PLANNING CONSULTATION RESPONSE

Application No	2026/0247
Proposal	Demolition of existing dwelling (retrospective), and the erection of 6 dwellings with associated works.
Address	177 High Street, Royston, Barnsley, S71 4RR
Date of Consultation Reply	3 rd July 2026
Consultee	Highways DC

OBJECT

Back Lane w

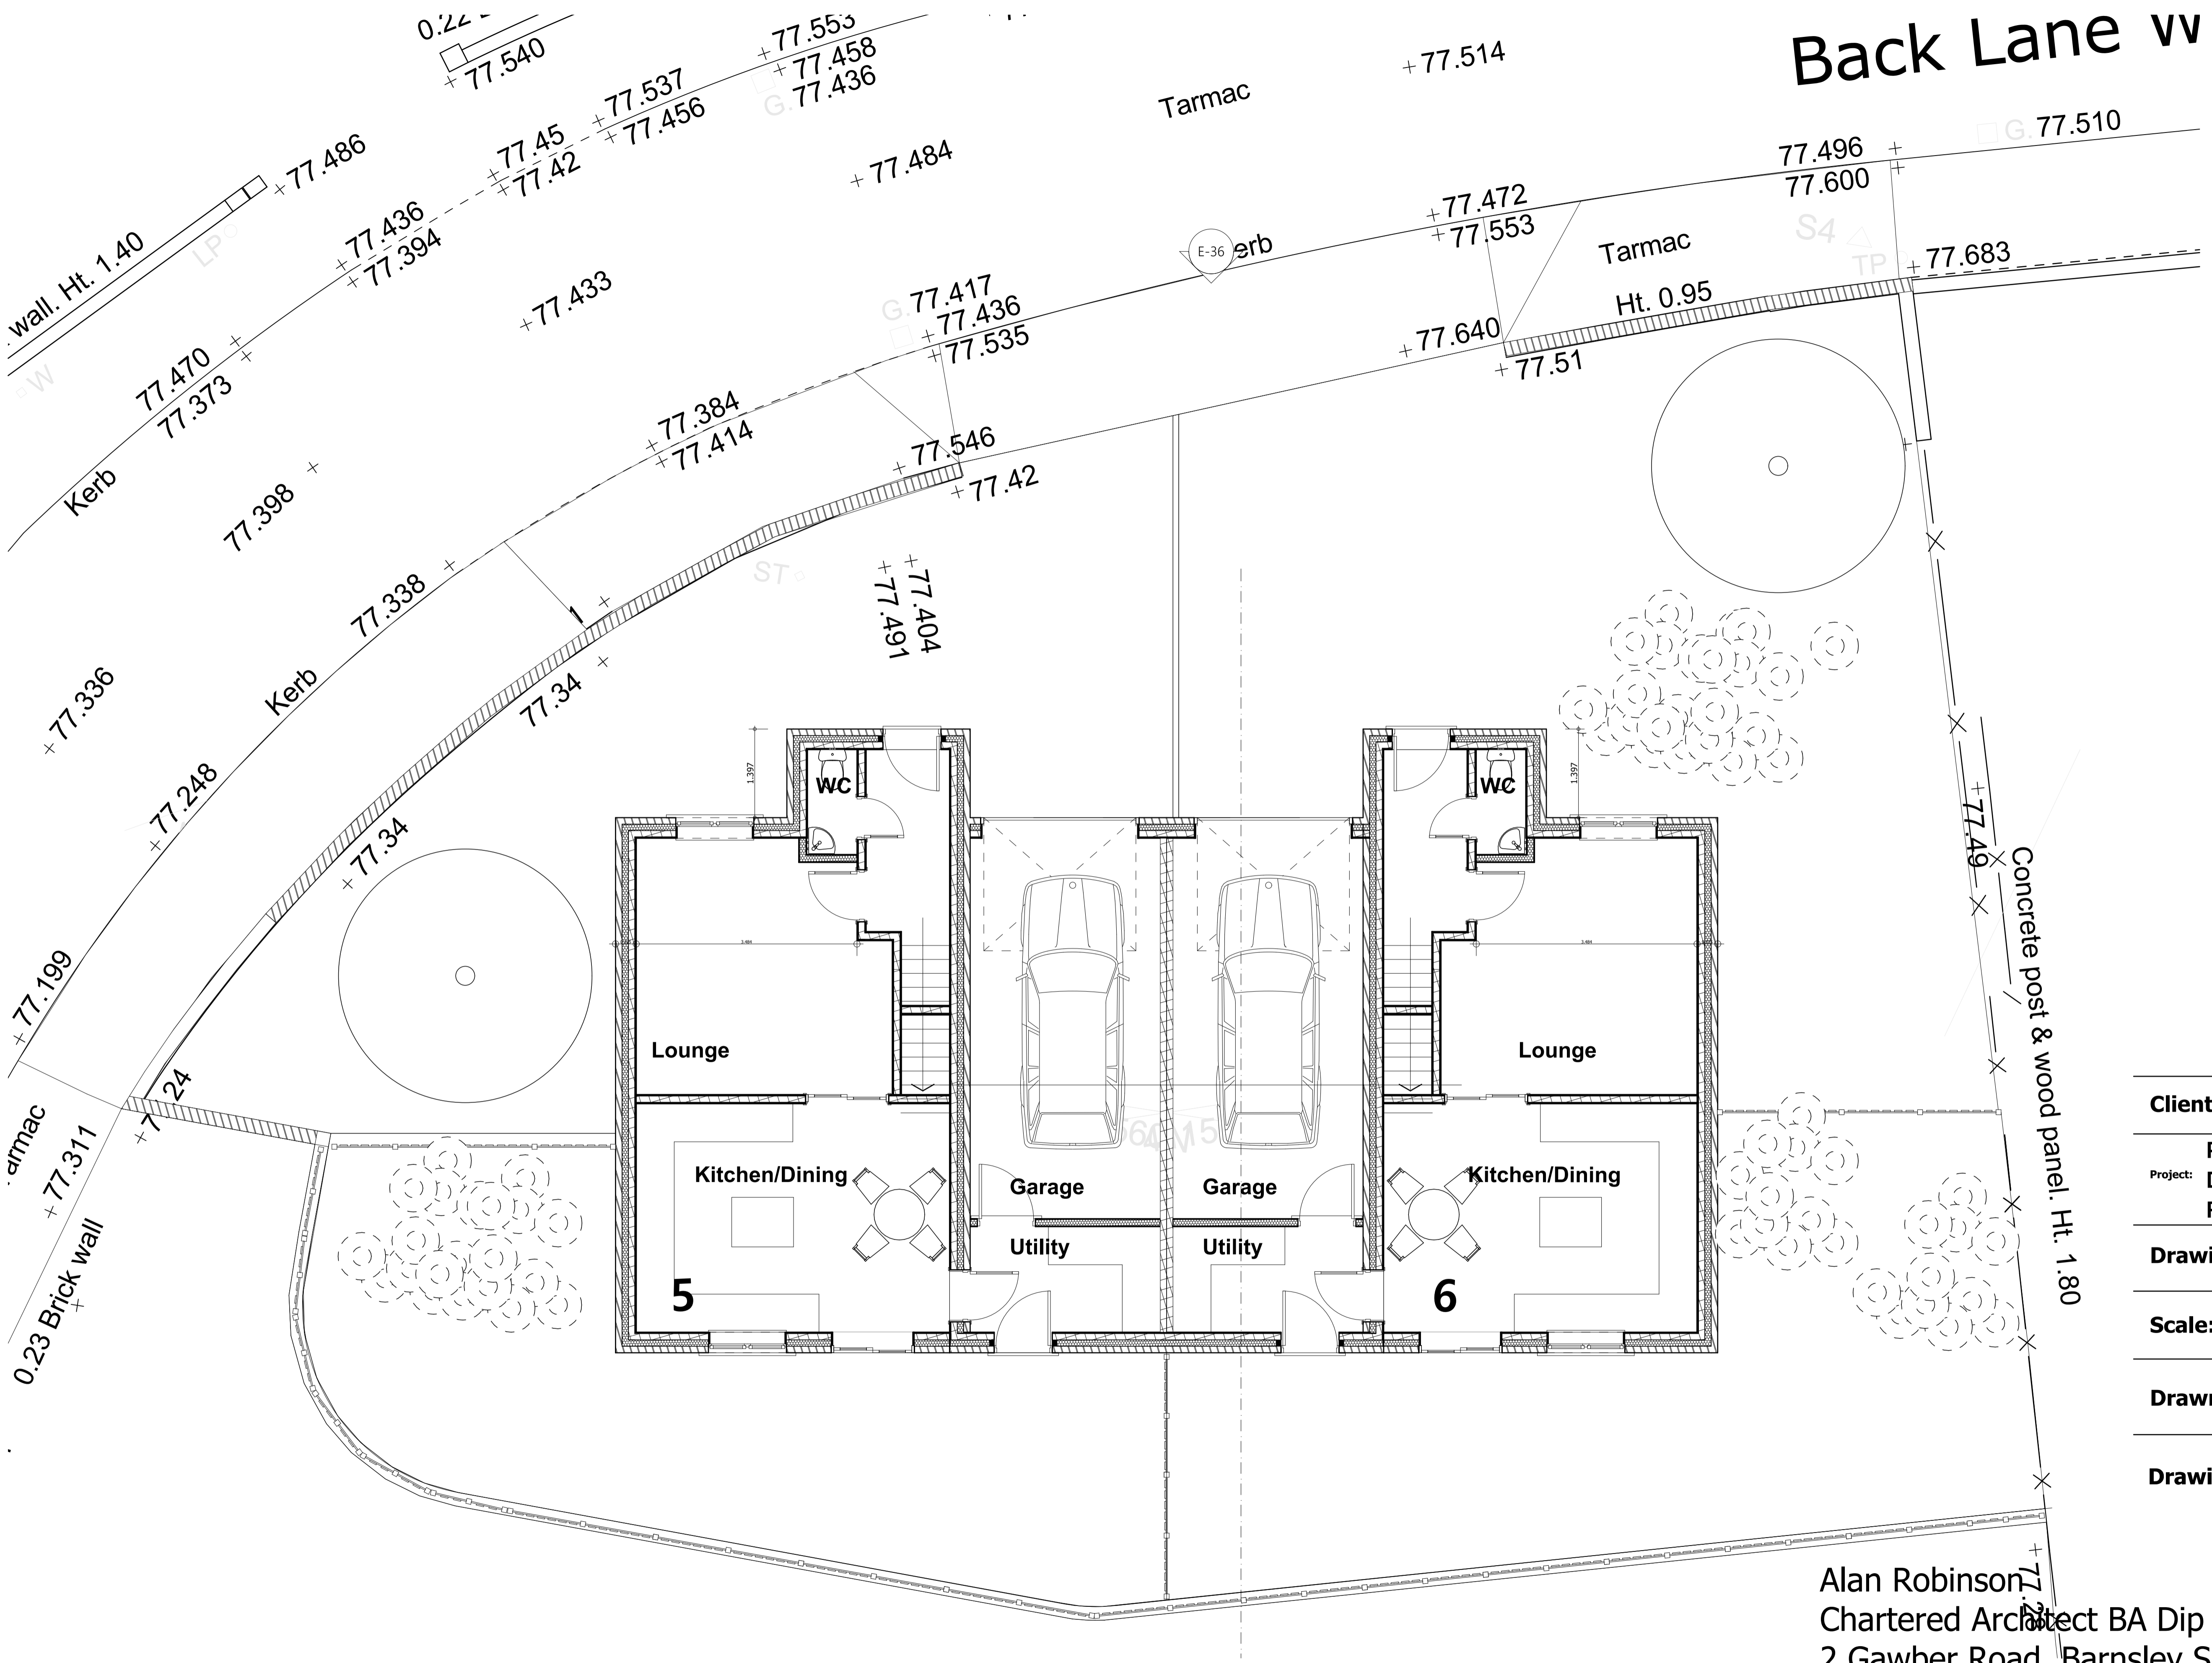
The site currently has a single vehicular access point off Back Lane West which served the now demolished single detached dwelling. The submitted scheme does not include the use of the existing access, the proposed residential development instead involves the creation of two new vehicular access points, both off Back Lane West.

The first of the proposed access points is along the western side of the site and takes the form of a private drive serving four dwellings (Plots 1 to 4). The second access is along the northern boundary and would serve two dwellings via a dropped kerb which would provide access to the adjacent driveways of Plots 5 and 6.

No details have been provided in terms of vehicular and pedestrian visibility at the access points. I would comment that the vehicular sight lines achievable from the private drive access are very substandard due to both the position of boundary walls/fences and the alignment of Back Lane West. Sight lines of approx. 2.4m x 7m to the left and 2.4m x 13m to the right are achievable, this is well below the standard 2.4m x 43m requirement and would result in the creation of a substandard vehicular access, to the detriment of highway safety.

It is evident that a significant amount of on-street parking occurs along Back Lane West to both sides of the road including along the site boundary. The creation of the two proposed vehicular access points would reduce the number of locations available to park on-street, this would increase the likelihood of vehicles being parked in and around the Back Lane West/High Street priority junction.

The proposals require the provision of two visitor parking spaces, but none are provided; this would further increase the demand for on-street parking spaces likely resulting in vehicles being parked indiscriminately on the public highway, to the detriment of highway safety.

-The parking spaces of Plots 1-4 are considered to be inaccessible due to the narrow width of the private drive. The 3.3m to 4.5m width is insufficient to allow for sufficient access/egress; a minimum 6m 'aisle width' of manoeuvring room should be provided for all parking spaces.

-The parking spaces of Plots 2 and 4 are undersized, all spaces should have minimum dimensions of 2.5m x 5m which means that the two-space parking bays should have a minimum width of 5m rather than the current 4.5m width.

-No information has been provided with regard to the proposed arrangements for refuse storage and collection.
